Application No: A/82/20/HH
Site Address: Harcourt West Drive Angmering BN16 4JE
Description of works: Extend domestic single storey garage and single storey enclosure to existing pool.

Thank you for your internet representation made on 30th June 2020 which has been recorded as an objection with the comments as follows:

<table><tr><td>PROJECT HARCOURT West Drive. Angmering Littlehampton. BN16 4JE</td><td colspan="3"></td></tr><tr><td>DRAWING PROPOSED PLAN and ELEVATIONS</td><td colspan="3"></td></tr></table>

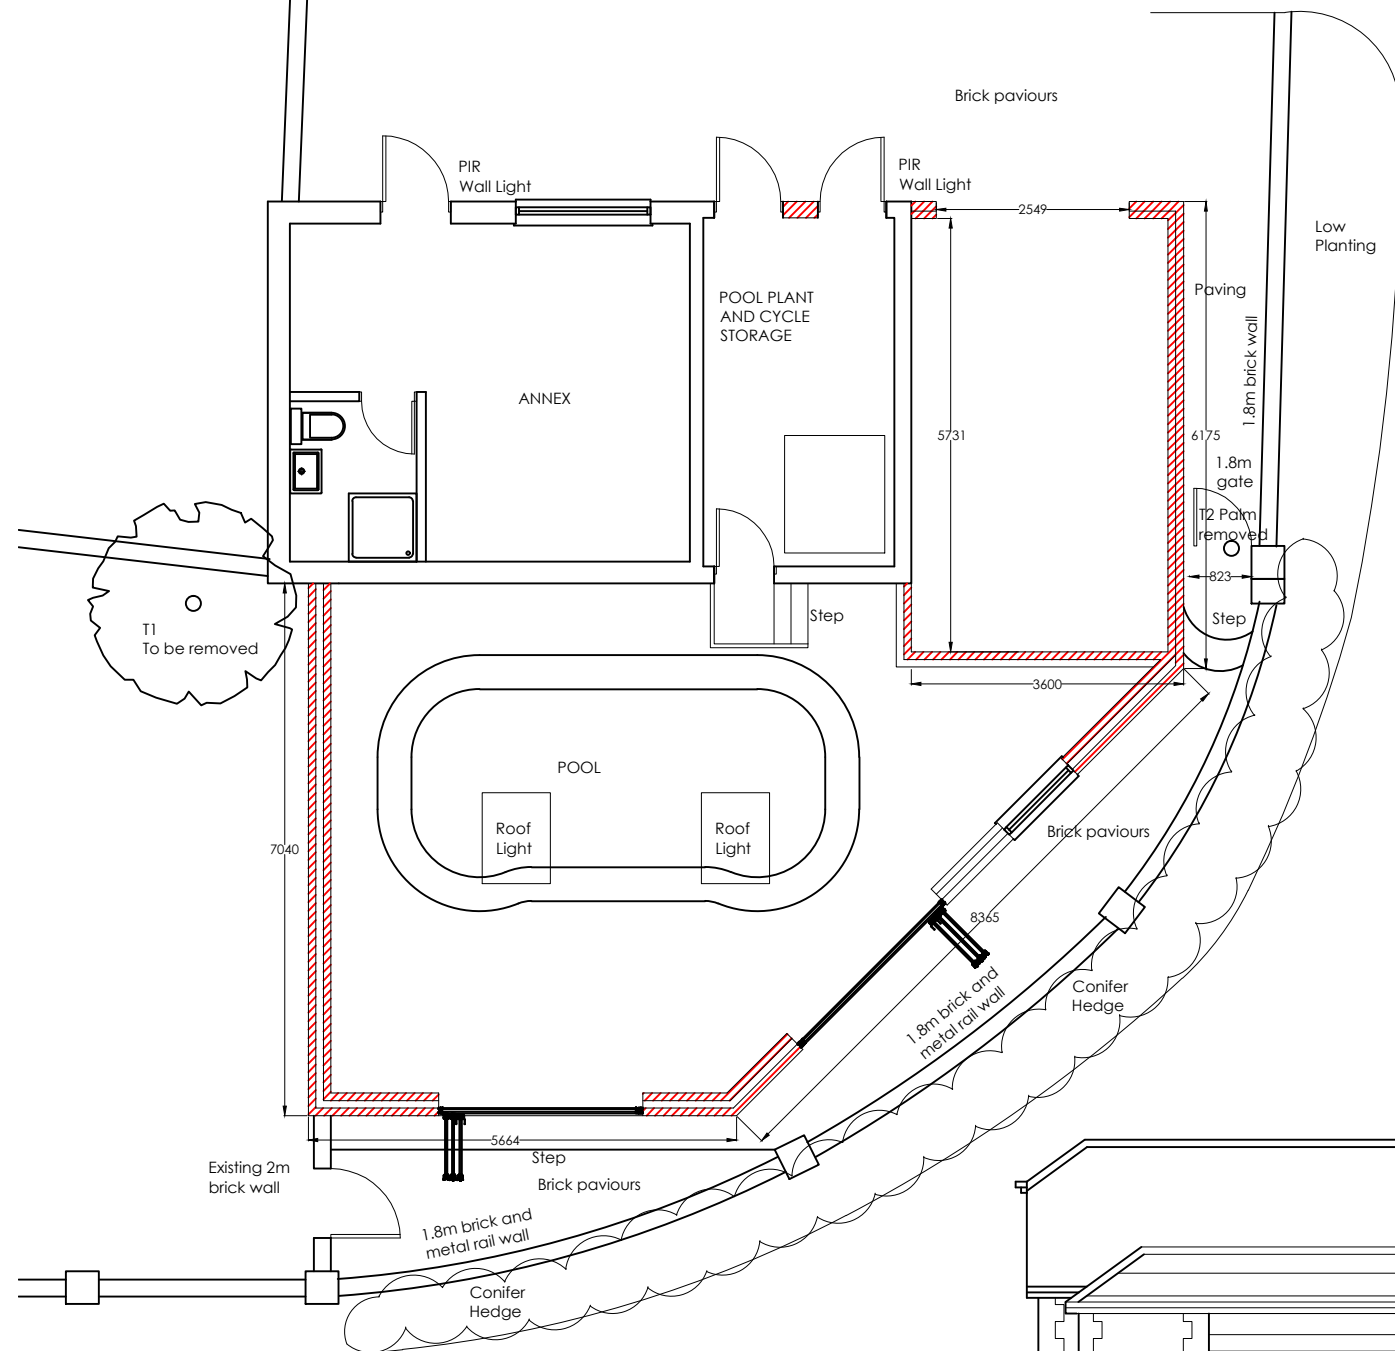
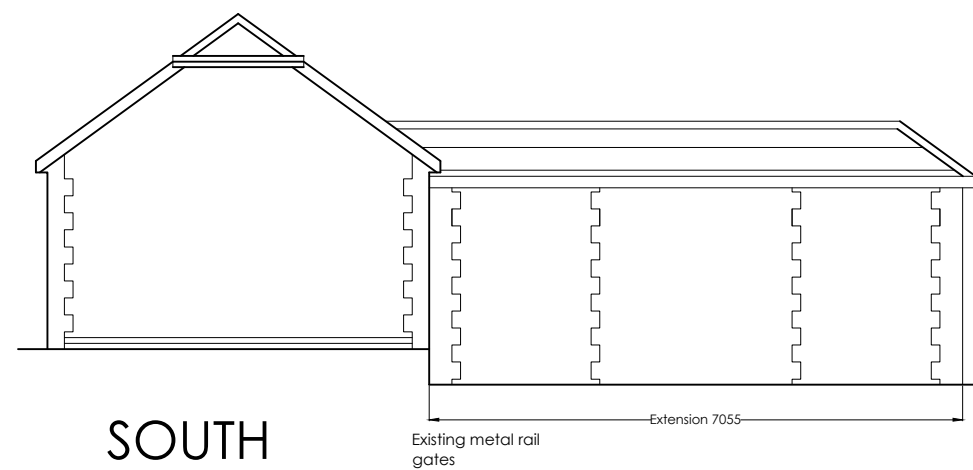
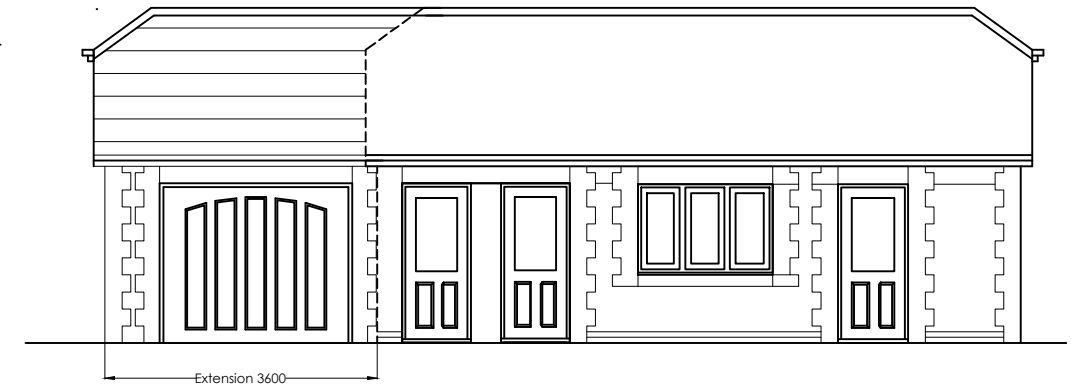
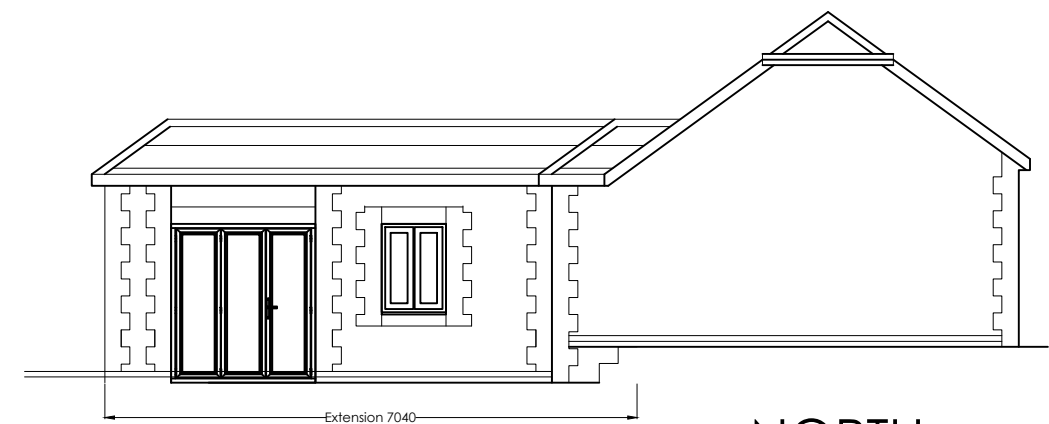
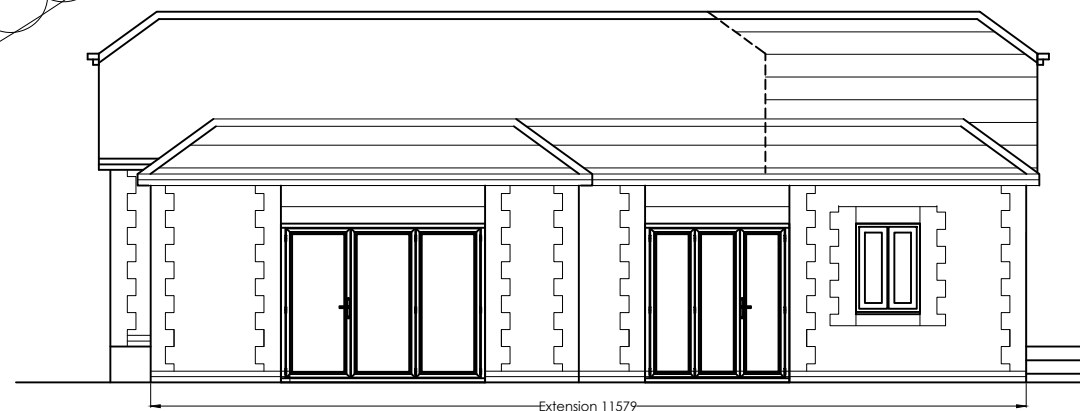
I object to this application as the submissions mislead what the effect on West Drive would be. The photographs submitted show every angle of this proposal except the most important one which is the view from West Drive heading towards the Golf Club with the location of the new build on the left. The building of a standard height property will make a change to the street scene and will be overbearing.
